From: [REDACTED]
To: [Norfolk Vanguard](#)
Subject: VATTENFALL NORFOLK VANGUARD - Registration identification number: 20012656
Date: 29 January 2019 21:13:43

Oulton Parish Council submits these comments as part of the Examination of Norfolk Vanguard at Deadline 2.

Norfolk Vanguard Offshore Wind Farm Plan Showing Hornsea Project Three Compound at Oulton

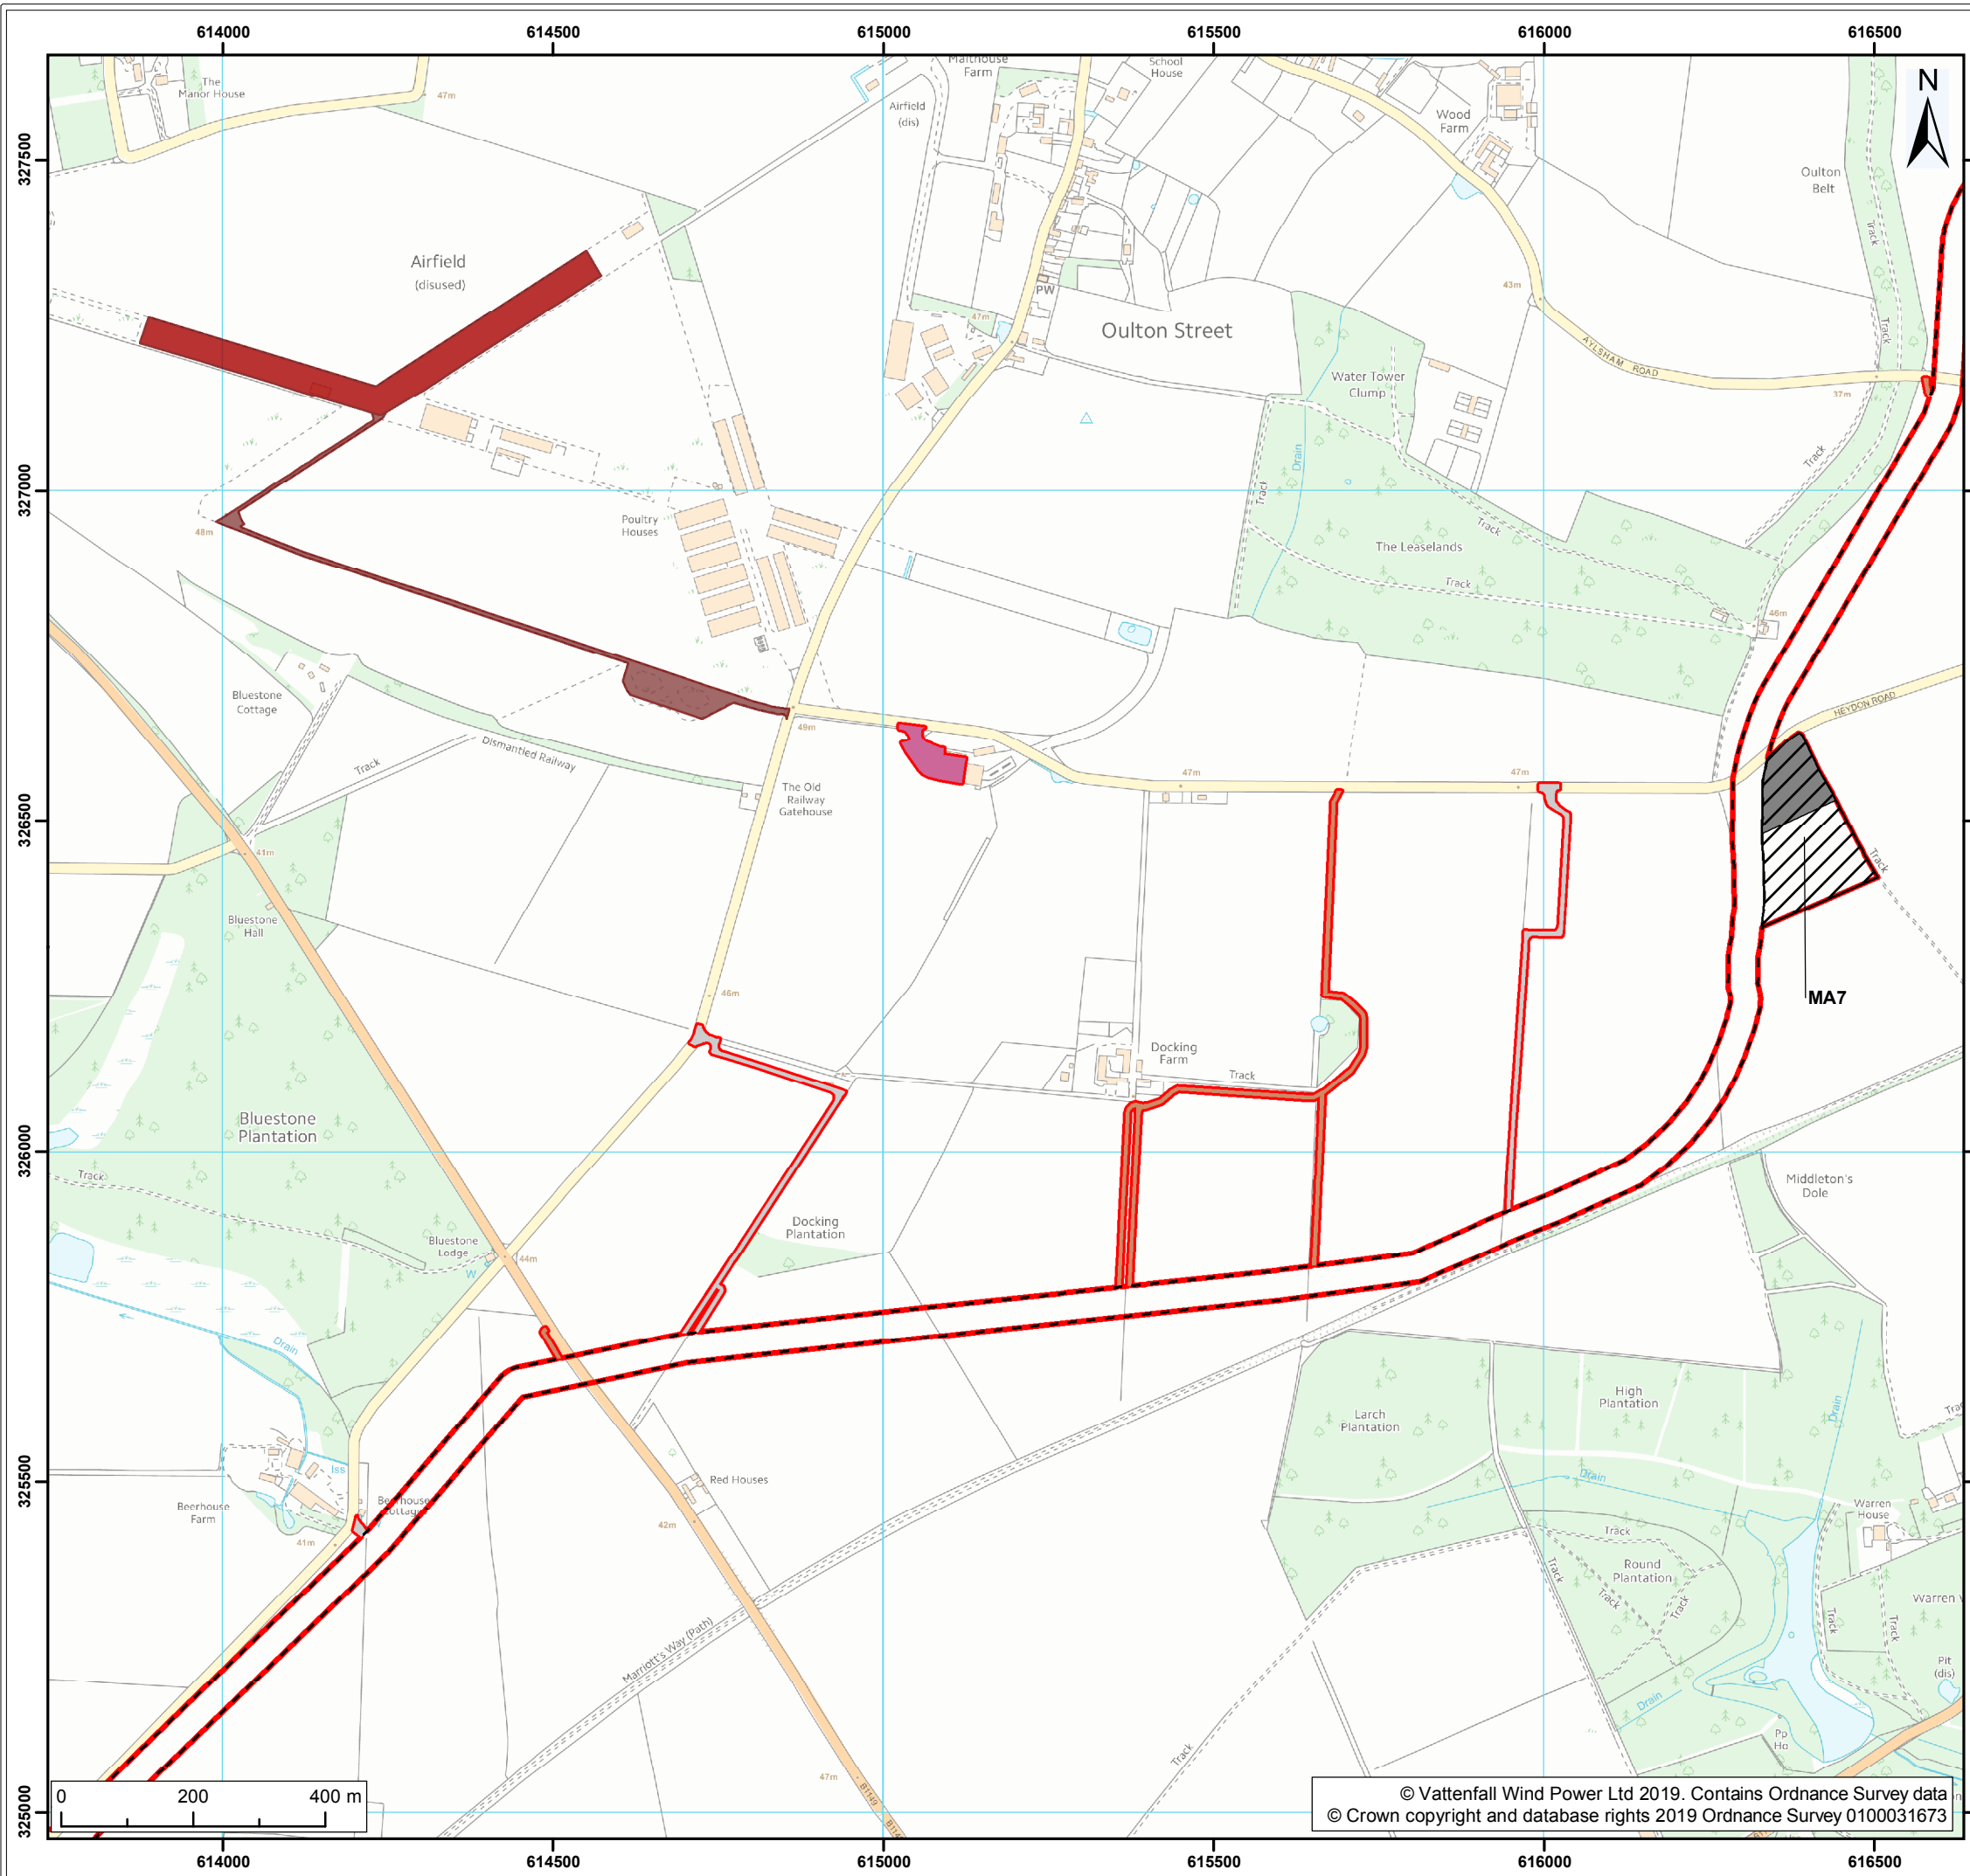
OPC would like to comment that LINK 68 is also the access route to the **Cable Logistic Area**. As OPC previously pointed out, the Cable Logistic Area is only mentioned on maps; there are no data in any documents specifically describing its location, function or reason for selection. This area was a late addition and **only appeared on final maps**.

OPC is very concerned that it appears the Cable Logistic Area is the only one for the whole project, and it is unclear whether the traffic figures submitted for LINK 68 also include cable drums going to the Cable Logistics Area. We seek clarification on whether this area is being utilised to store cable for other parts of the cable route and if this is factored into the final traffic numbers.

Vattenfall have not produced plans as to how traffic travelling along The Street from B1149 to LINK 68/MA7/Cable logistic area can safely interact with existing traffic (agricultural/local) and the large volume of traffic generated by Hornsea Project Three.

A vehicle Pilot Scheme has been suggested but no further information on traffic management has been forthcoming. It is difficult to see how such an operation will work without the danger of held traffic queuing onto the busy B1145 junction. **Orsted Hornsea Three** have proposed a series of road modifications for 'The Street' to enable their traffic to access the Main Construction Compound. OPC cannot understand why similar proposals have not been put forward by Vattenfall, given the same route, type of vehicle and very similar traffic volumes. OPC assumes that some sort of arrangement will be negotiated if both projects progress and run concurrently, but **if Vattenfall are the first or only project** it is hard to understand why changes to the road are not being considered at this stage. OPC would like to know if a road safety audit or traffic surveys have been carried out for 'The Street'(Link 68) and Link 75.
